# Rezoning Transportation Analysis

Petition Number: 2023-121

**From:** Jake Carpenter, PE

Date	Description
10-25-23	First Review (JP)

**EX-1.0**

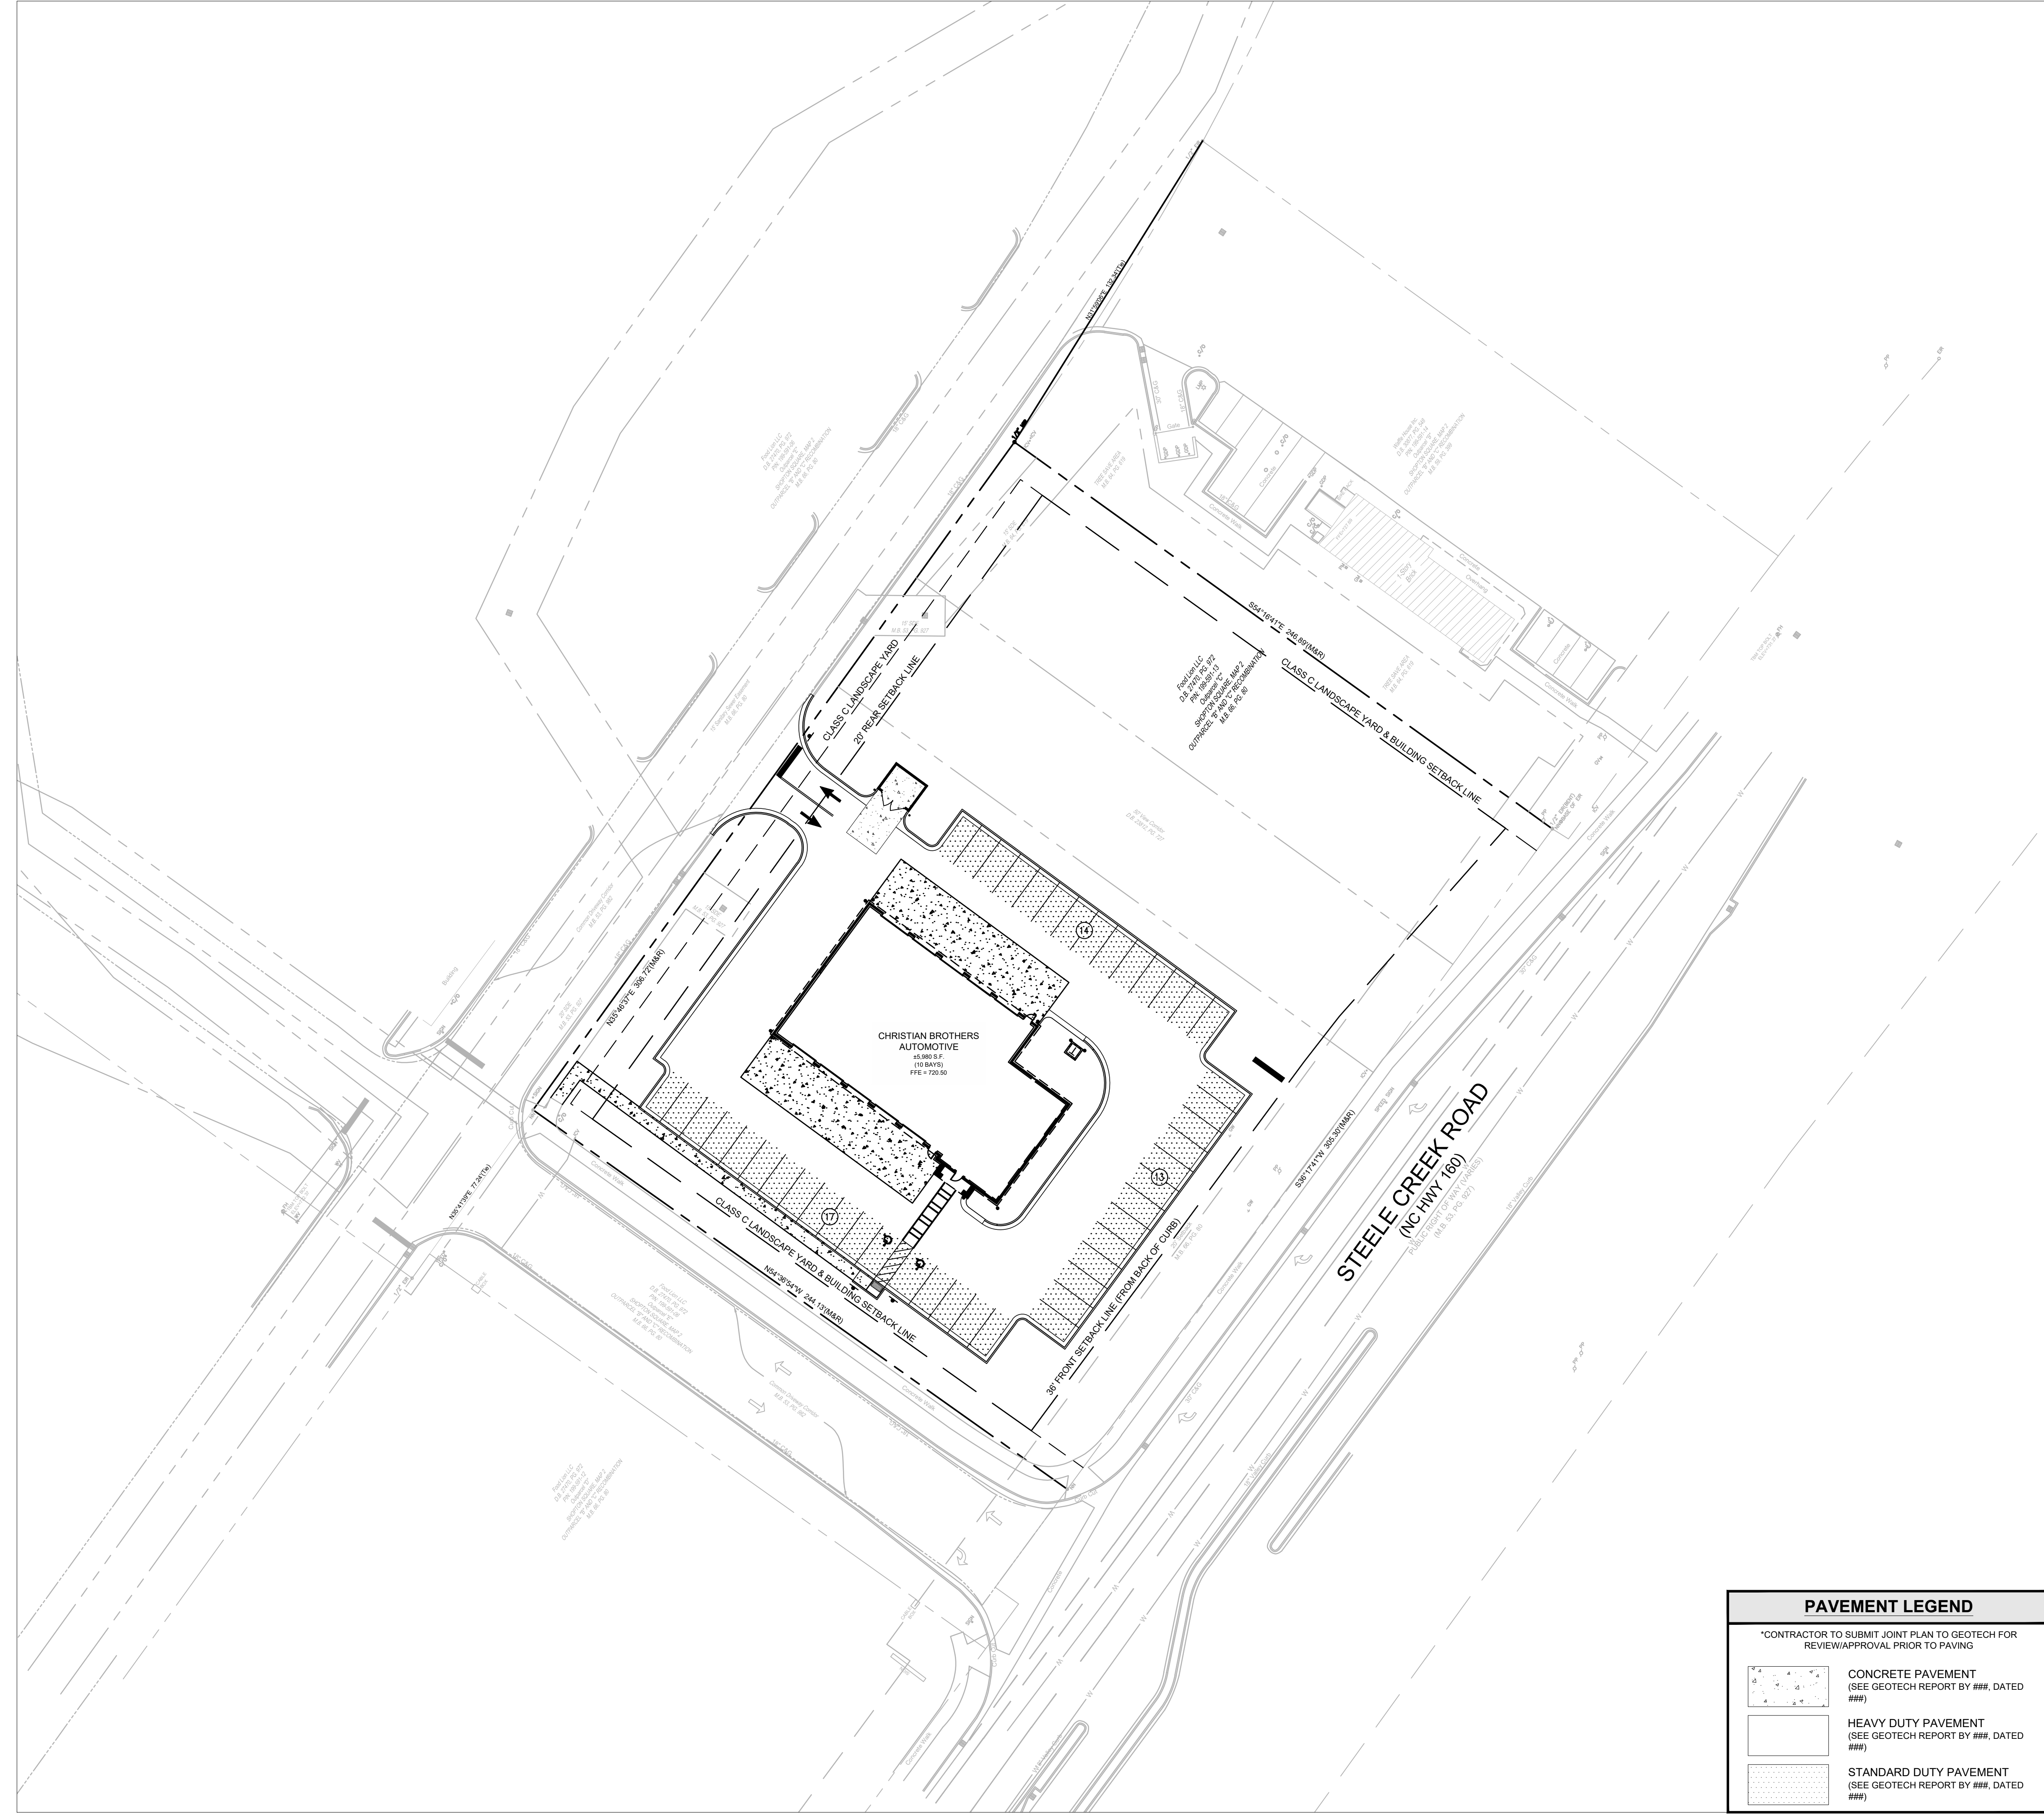
- a. **Steele Creek Road:** future location of curb and gutter is in its existing location.

Label and dimension the curb and gutter from the centerline for each road on the site plan.

- 3. Revise site plan and conditional note(s) to label and dimension the right-of-way from the road centerline.
- 4. Revise site plan and conditional note(s) to commit to upgrading the existing streetscape to 8-foot sidewalk and 8-foot planting strip across the site's frontage on Steele Creek Road in accordance with the UDO section 32.7(D)(2)(a)(iv).

5. Revise site plan and conditional note(s) to commit to upgrading the ramp at the corner of the property to meet ADA/PROWAG standards.
